OAKLANDS FARM SOLAR PARK

The Applicant's Comments on Responses by Interested Parties to the Third Written Questions and other Submissions made at Deadline 6 December 2024

Document Ref: EN010122/D7/15.4

Figure 1e: Habitat constraints plan

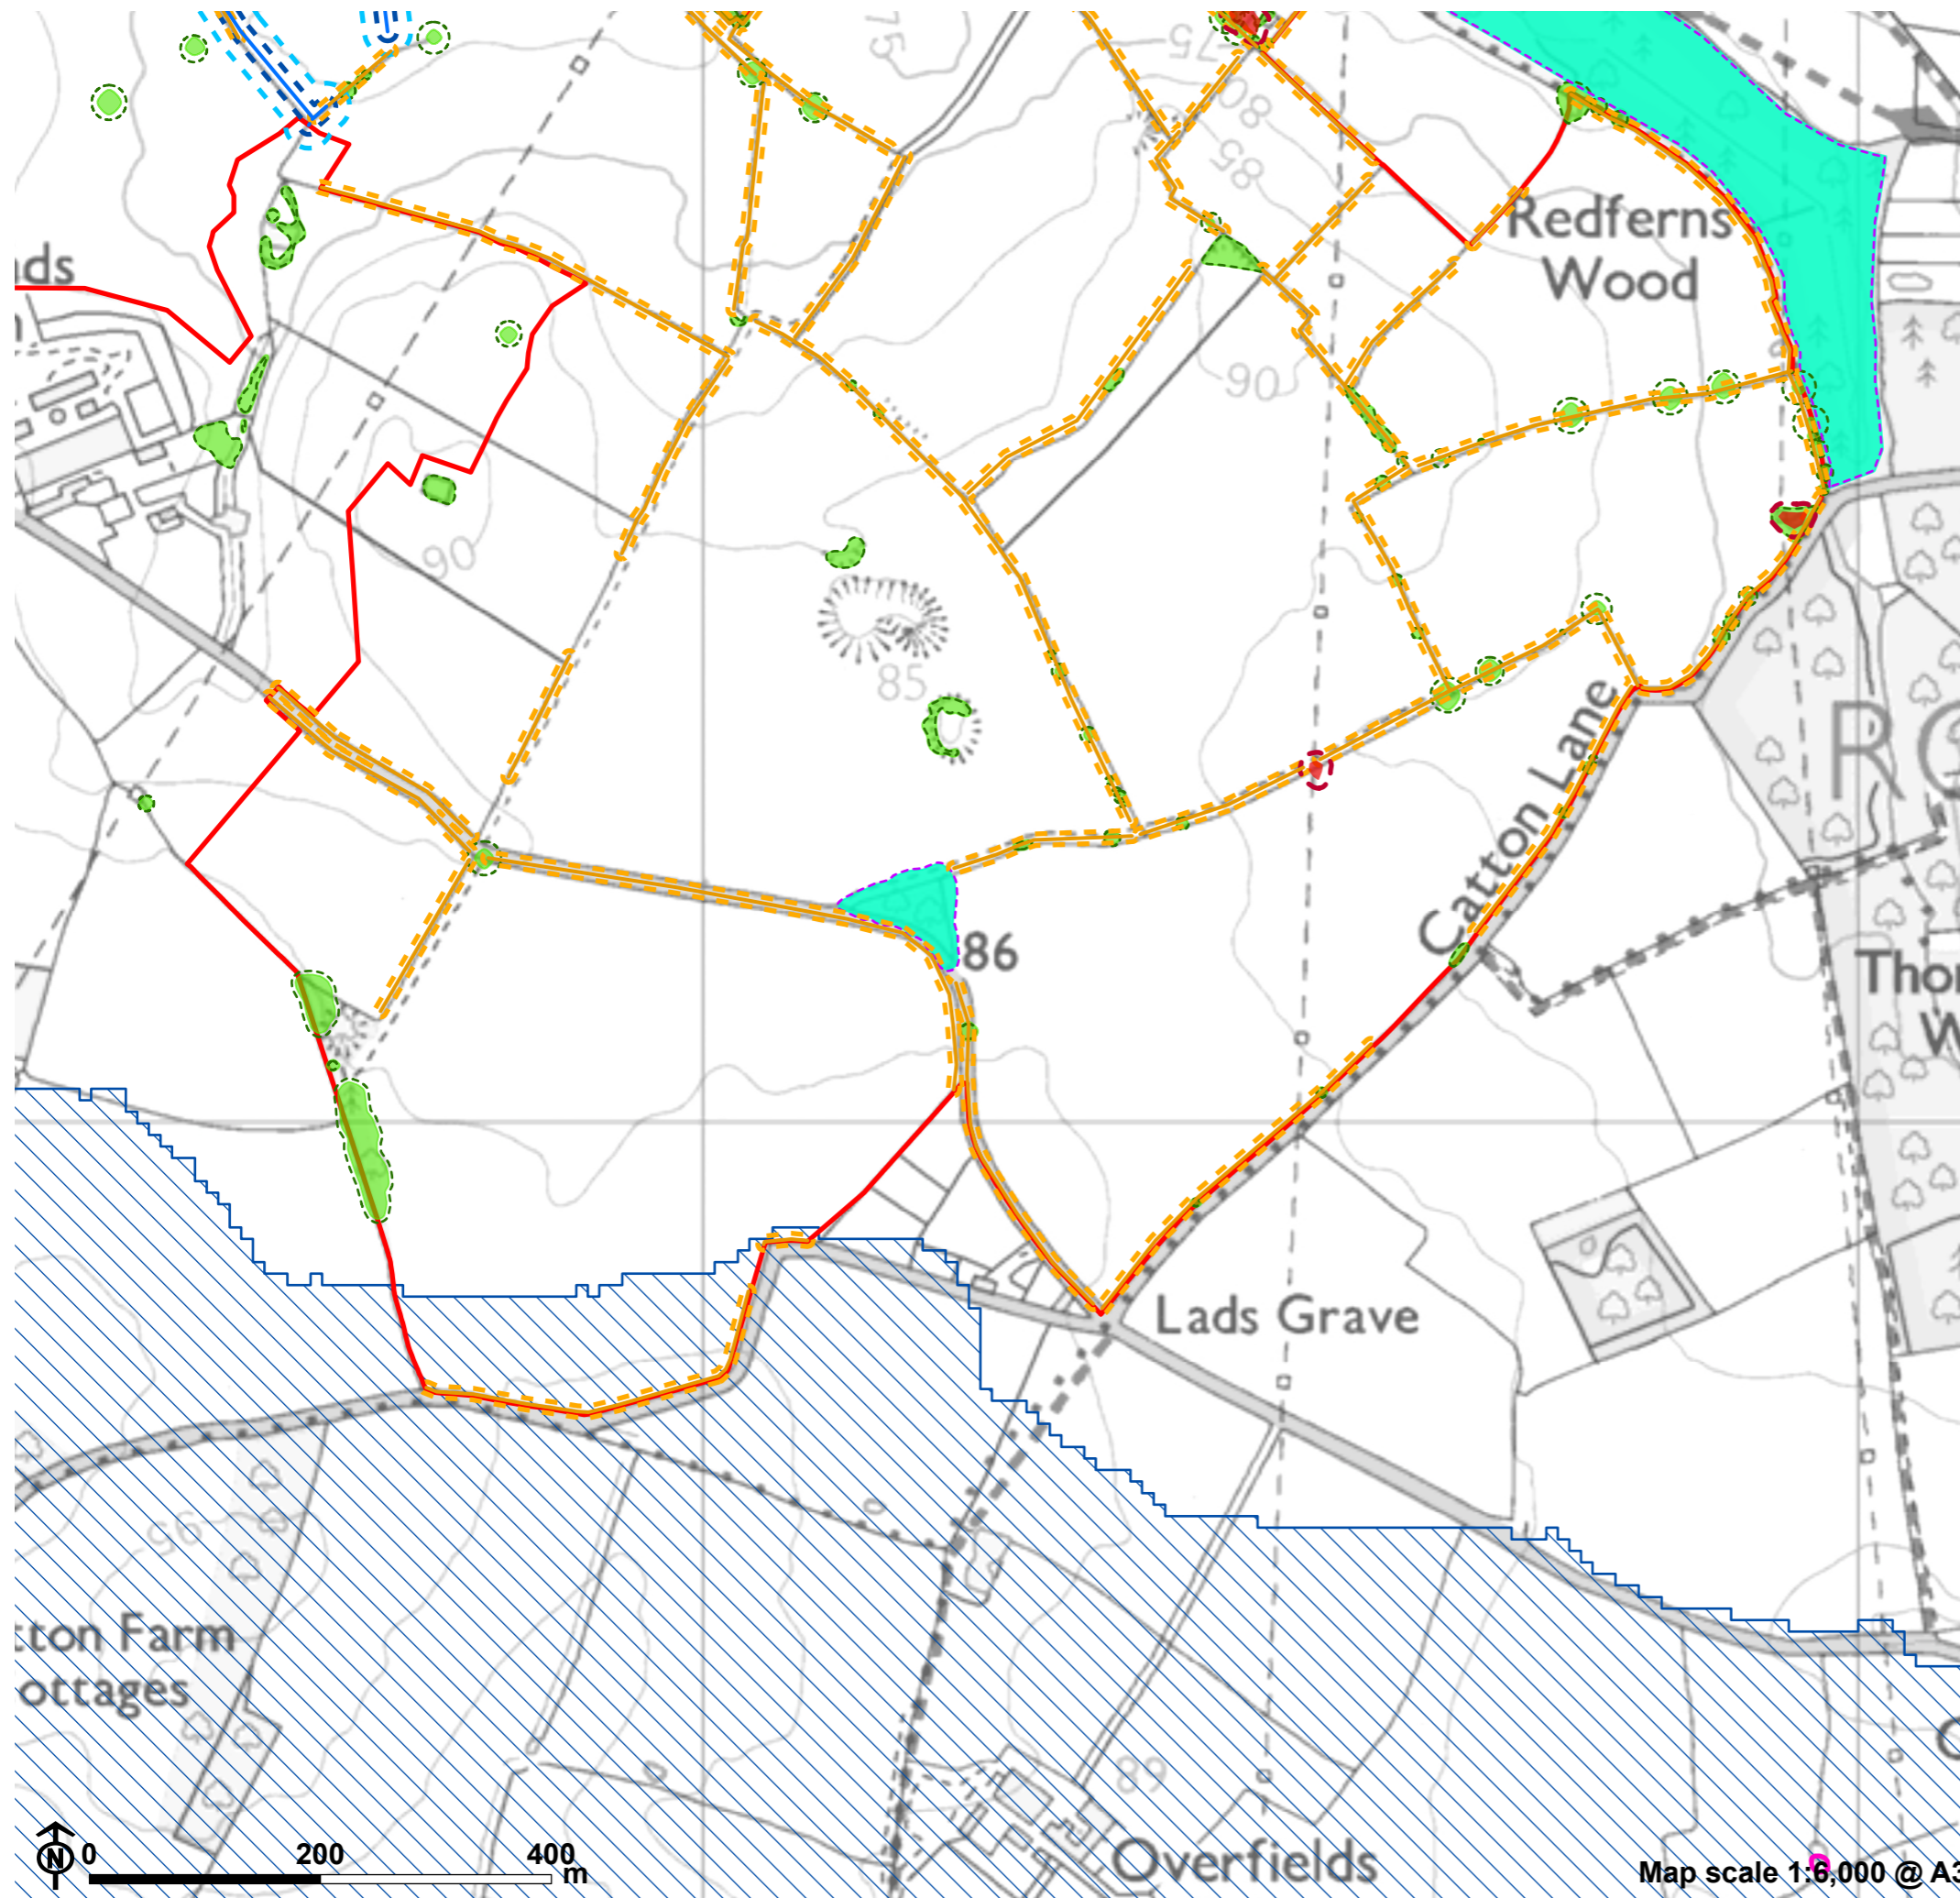
7.3	Applicant, SDDC, DCC			
	<p>Habitat Constraints Plan</p> <p>SDDC [REP4-014] and DCC [REP4-012] referred to the need for a Habitat Constraints Plan with interpretable maps to provide the necessary details and extent of site clearance works relating to buffer zones to sensitive features such as ancient/ veteran trees, other retained trees, ponds, watercourses, hedgerows and woodlands.</p> <p>The Outline CEMP [REP5-011] includes provisions for a Habitats Constraint Plan [Section 2.8.5] and buffers [Sections 2.6.4, 2.6.5, 2.8.2, 2.8.3, 2.8.5, and 2.8.6]. The Applicant provides a series of interpretable maps of habitat constraints [REP5-030].</p> <p>a) Please could the Applicant add the draft interpretable maps to the Outline CEMP [REP5-011] and secure that interpretable maps be included in the final CEMP?</p> <p>b) Please could SDDC and DCC comment?</p> <p>c) Please could SDDC and DCC also summarise any outstanding concerns at Deadlines 7 and 8 with suggestions about how they might be addressed?</p>

Applicant at D6	SDDC at D6	DCC at D6	Applicant at D7
	<p>a) The draft Habitat Constraints Plans have been added to the Outline CEMP at Appendix 4. A final version of the Habitat Constraints Plans will be delivered as part of the final CEMP as secured by Requirement 9(2)(n).</p> <p>b) No response required.</p> <p>c) No response required.</p>	<p>b) SDDC have reviewed those interpretable maps and they provide useful clarity and should be attached to the Outline CEMP for further comprehensive review.</p>	<p>DCC welcomes the inclusion of the habitats constraints plans referenced in the OCMP at 2.8.5 including buffer zones, and requirement 9 for approval of the LPA prior to construction.</p>	<p>The Applicant welcomes the comments from both SDDC and DCC confirming acceptance of the draft Habitat Constraints Plans. No further action is required.</p>

Plate 15.3: ALC Results (extract from Appendix 15.1)

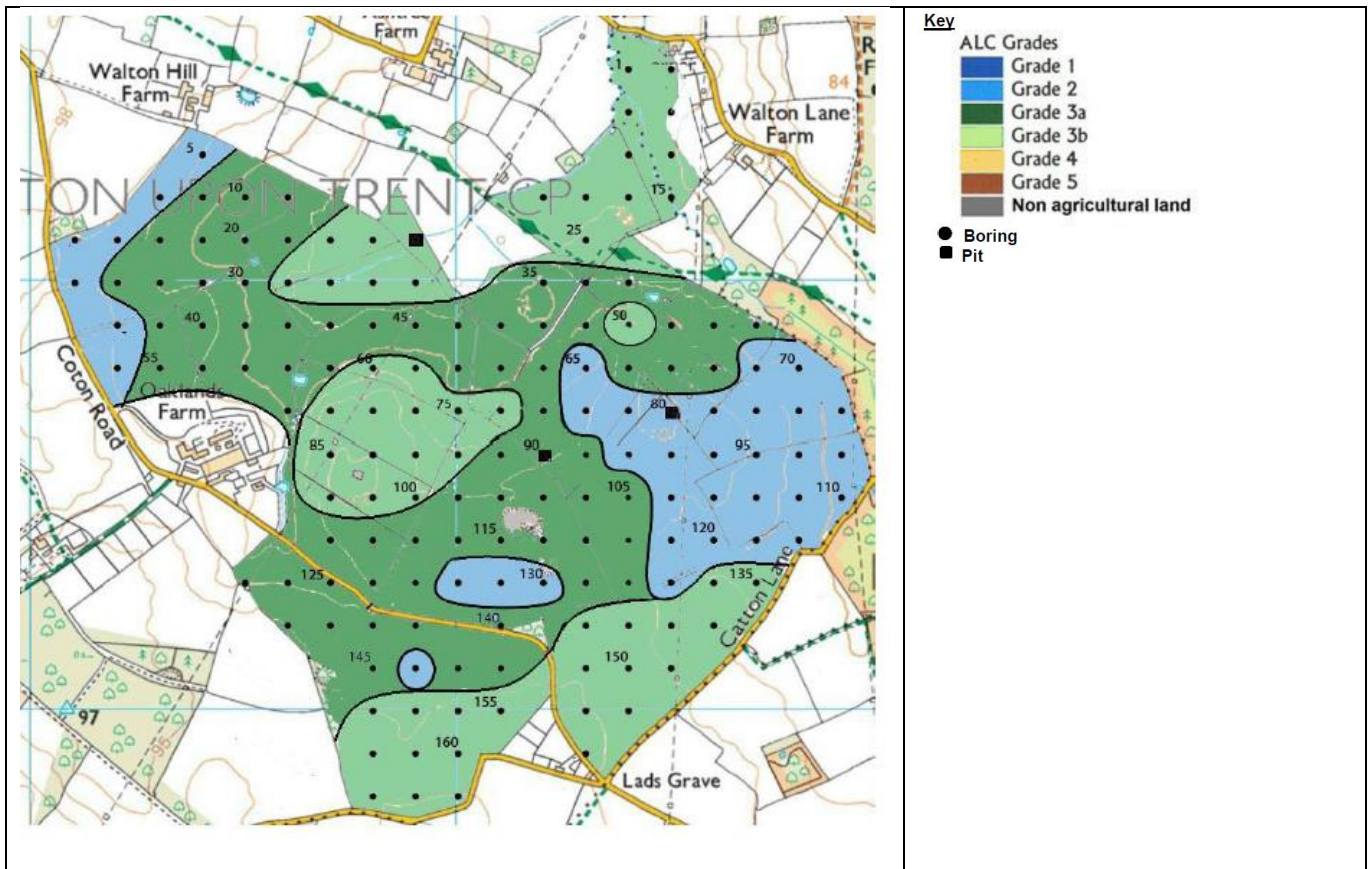
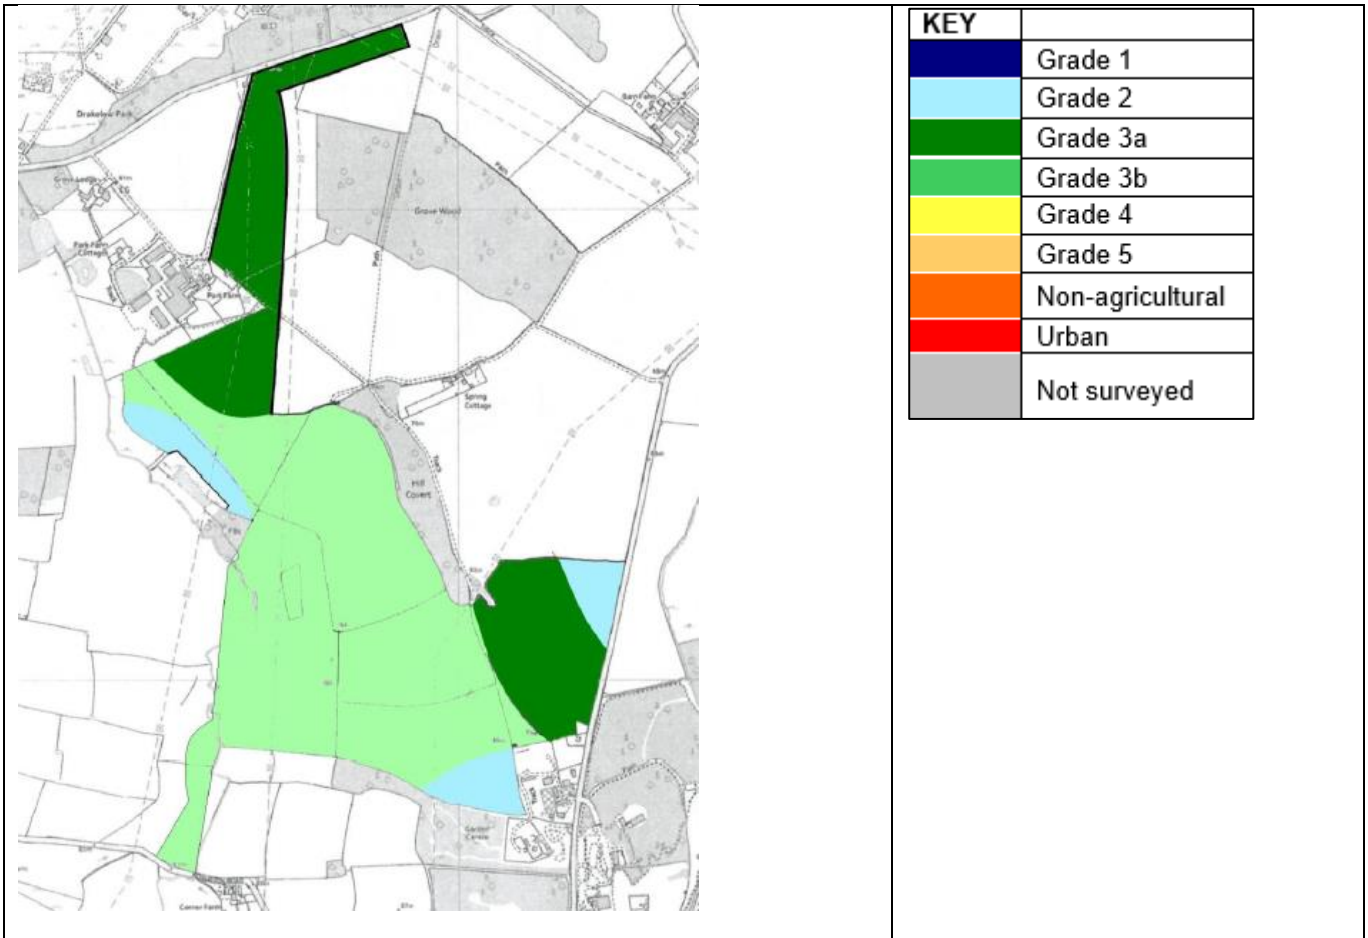
<p>6.3 Applicant, NE, SDDC</p> <p><u>Agricultural Land Classification (ALC)</u></p> <p>NE [AS-022] [REP1-037] raise various concerns regarding ALC, including:</p> <ul style="list-style-type: none"> • where Best and Most Versatile (BMV) agricultural land is not expected then a semi detailed survey (1 auger per 2 ha plus representative pits) will suffice; • in areas that BMV agricultural land is expected then a full ALC (1 auger per ha plus representative pits) must be undertaken; • it does not concur with the assumption that land quality is mostly 3b within the cable route; • an ALC survey should be undertaken on the cable route; • in the absence of a detailed survey for most of the cable corridor it is impossible to provide an accurate baseline and demonstrate the likely potential impacts; • the survey requires an experienced ALC surveyor to make the correct professional judgements; • detail should be provided of the professional credentials and experience required of soil scientists (surveyors) experience carrying out ALC; and • the ALC survey will inform the SMP. <p>NE [AS-033] say that they have no further concerns regarding ALC survey methodology, but did not provide any further detail.</p> <p>The Applicant [REP3-032, REP4-011, REP5-024, REP5-025, REP5-026] has responded and provided an Additional Land Classification Survey at Park Farm [REP5-036].</p> <p>SDDC [REP5-039] generally concur with NE's comments, adding that soil scientists (surveyors) should be British Society of Soil Science standard, and that ALC survey must inform the SMP.</p> <p>a) Please could NE address each of the above concerns individually, in each case setting out whether it is satisfied, and either how it is satisfied or how it could be?</p>
